WEST SUSSEX COUNTY COUNCIL CONSULTATION

TO:	Armstrong Simmonds Architects FAO: Edmund Thomas Green
FROM:	Highways, WSCC
DATE:	30/07/2018
LOCATION:	90 & 91, South Terrace, Littlehampton, West Sussex, BN17 5LJ
SUBJECT:	PRE-45-18 Change use from existing leisure use of upper ground floor to form 3 flats. Extension of first floor to form 3 flats. Creation of 2 flats in roof space associated alterations to amenity and parking. Resubmission following LU/197/17/PL
DATE OF SITE VISIT:	n/a
RECOMMENDATION:	☒ Advice ☐ Objection ☐ Modification ☐ No Objection ☐ More Information ☐ Refusal
S106 CONTRIBUTION TOTAL:	n/a

The Highways Authority has been consulted for pre-application advice in regard to the change use from existing leisure use of upper ground floor of 90 & 91, South Terrace, Littlehampton to form 3 flats. Extension of first floor to form 3 flats. Creation of 2 flats in roof space associated alterations to amenity and parking. Proposed amendments following LU/197/17/PL.

Drawing Number:
955_90ST_D101.1

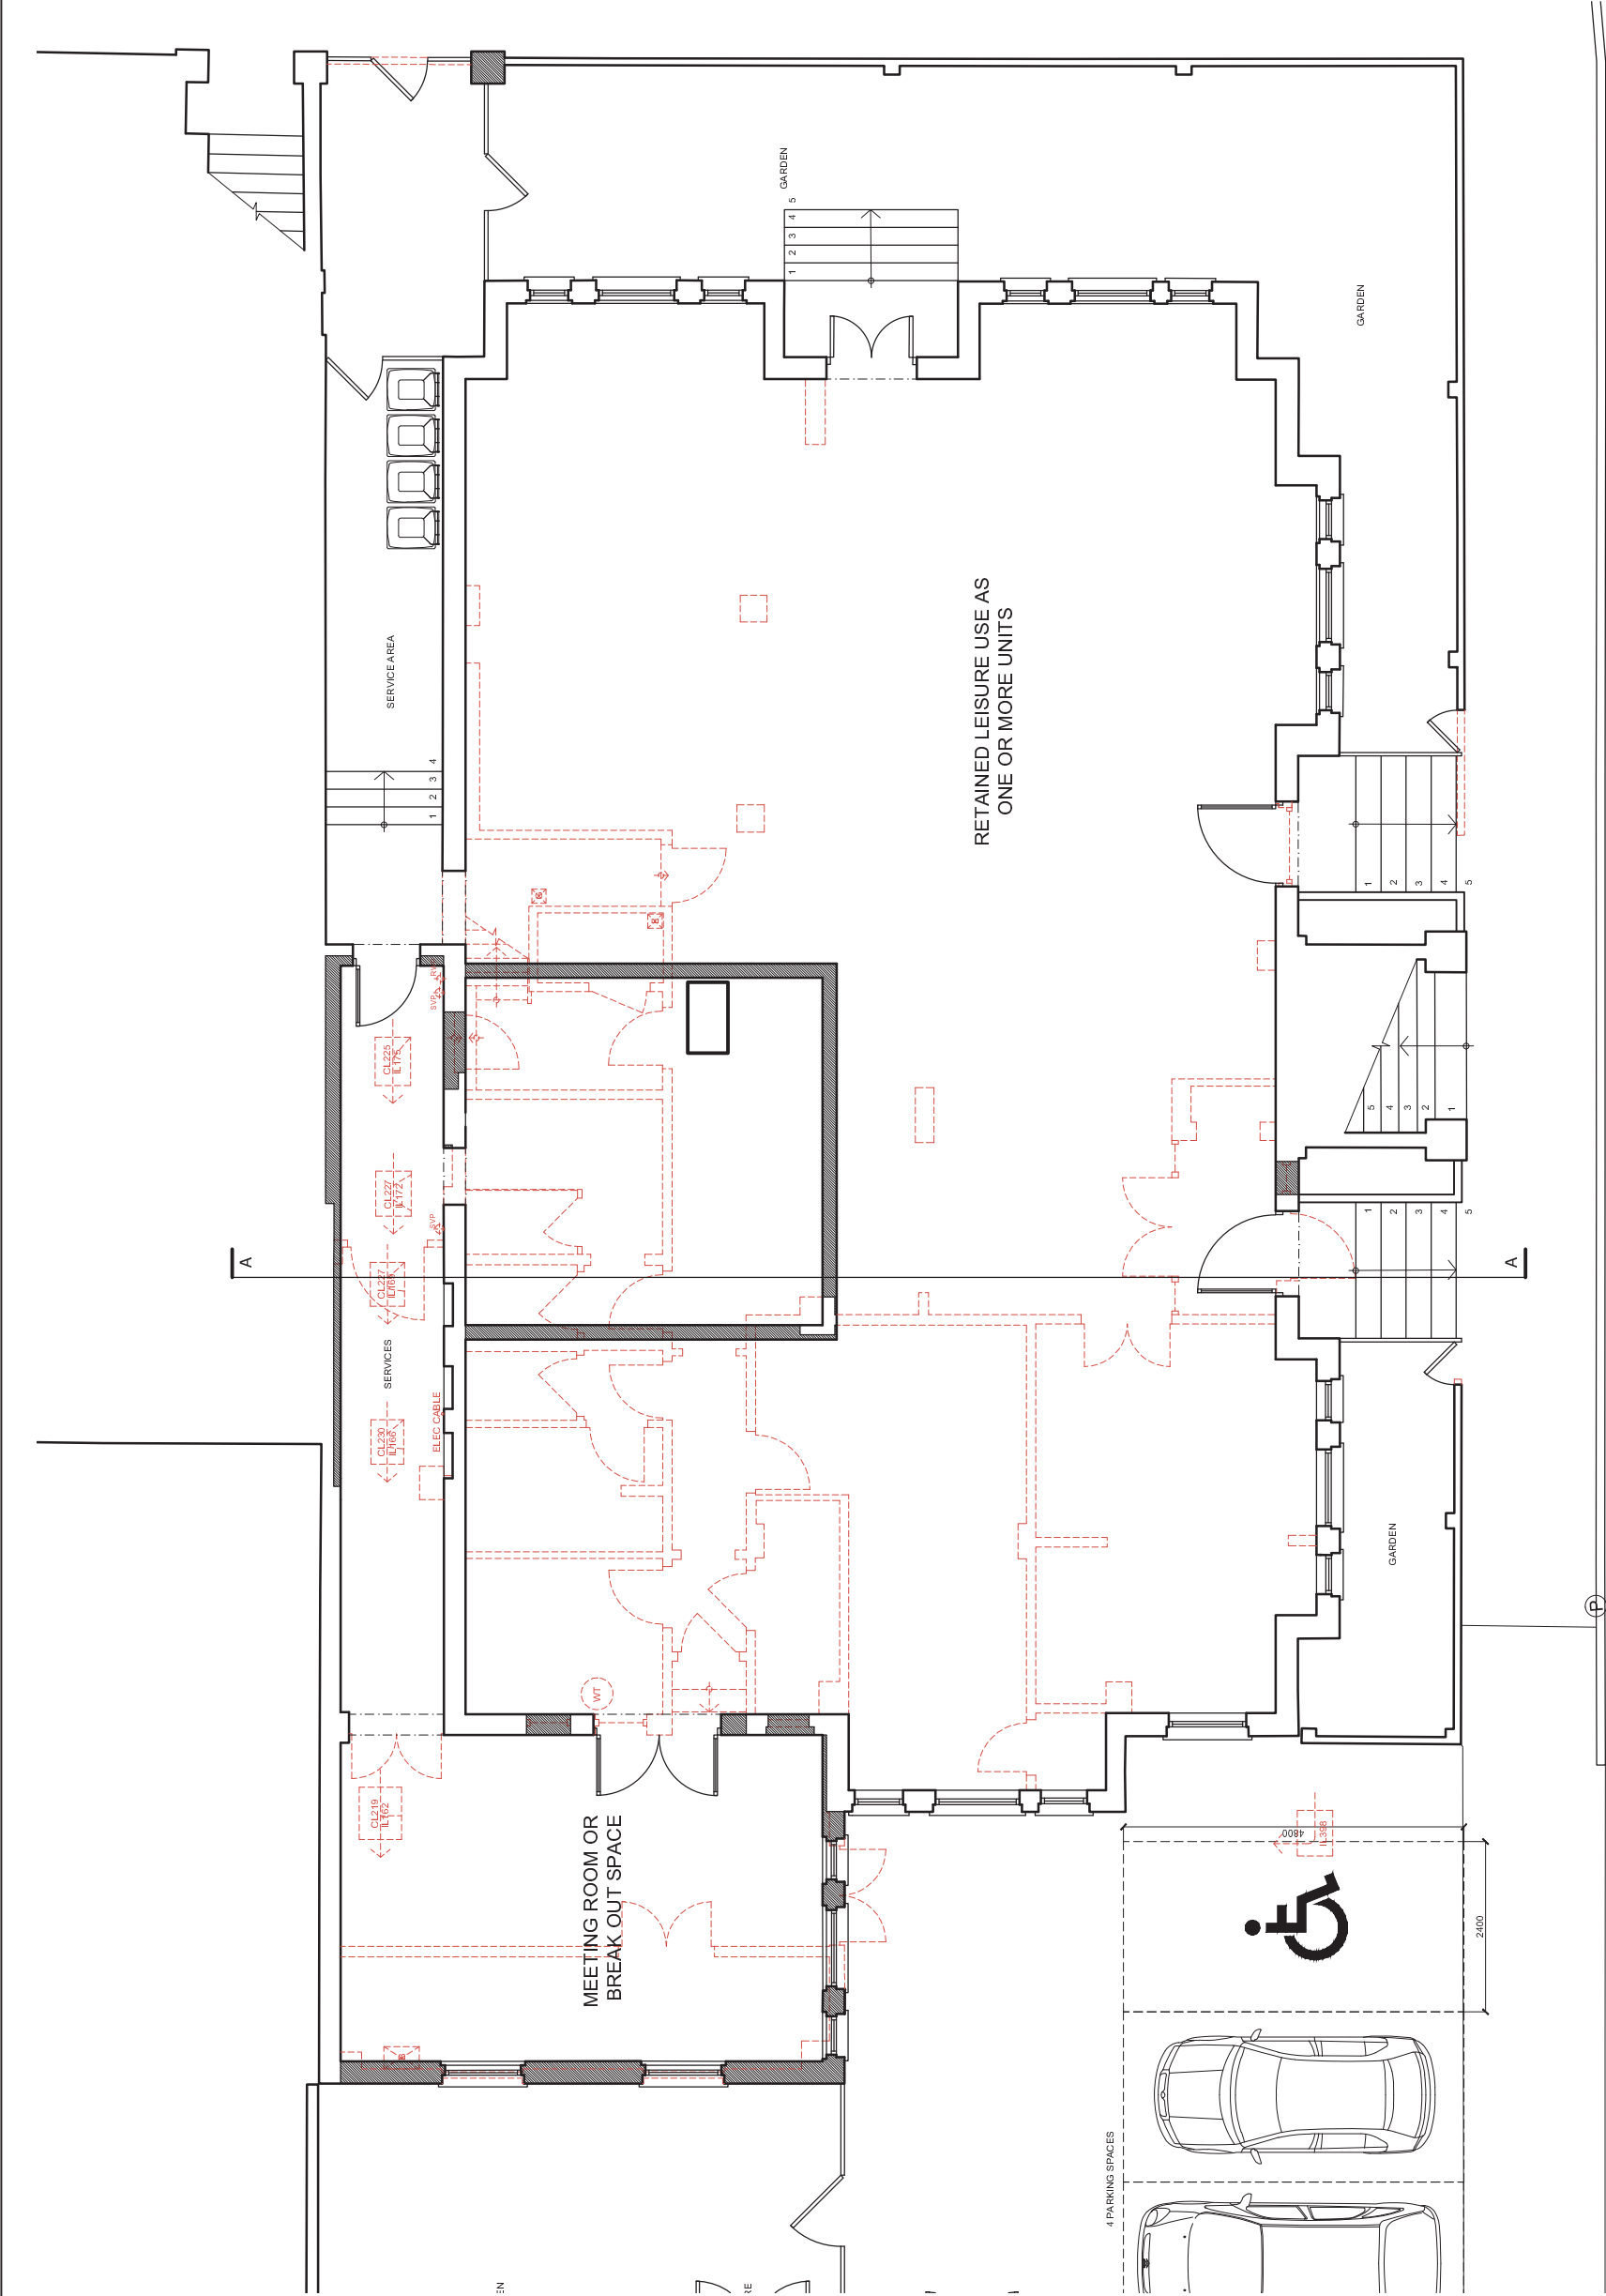
In highways terms this increase in residential units would increase the anticipated car parking demand created by the development. A total of 4 car parking spaces will be provided to serve the 8 flats, presumably on an unallocated basis.

Using the plans submitted it would be anticipated that a development of this size in this location would attract the demand for 6 car parking spaces. While there is a shortfall of 2 spaces the existing use of the site must be taken into consideration. The existing D2 use would have attracted a significant quantity of parking demand (1 space per 22sqm); taking into consideration the loss of D2 use class the overall parking demand of the proposed would be considered lower than the existing use of the site.

As such the Local Highways Authority does not consider that the proposal for would have 'severe' impact on the operation of the highway network, therefore is not contrary to the National Planning Policy Framework (paragraph 32), and that there are no transport grounds to resist an amendment of this basis.
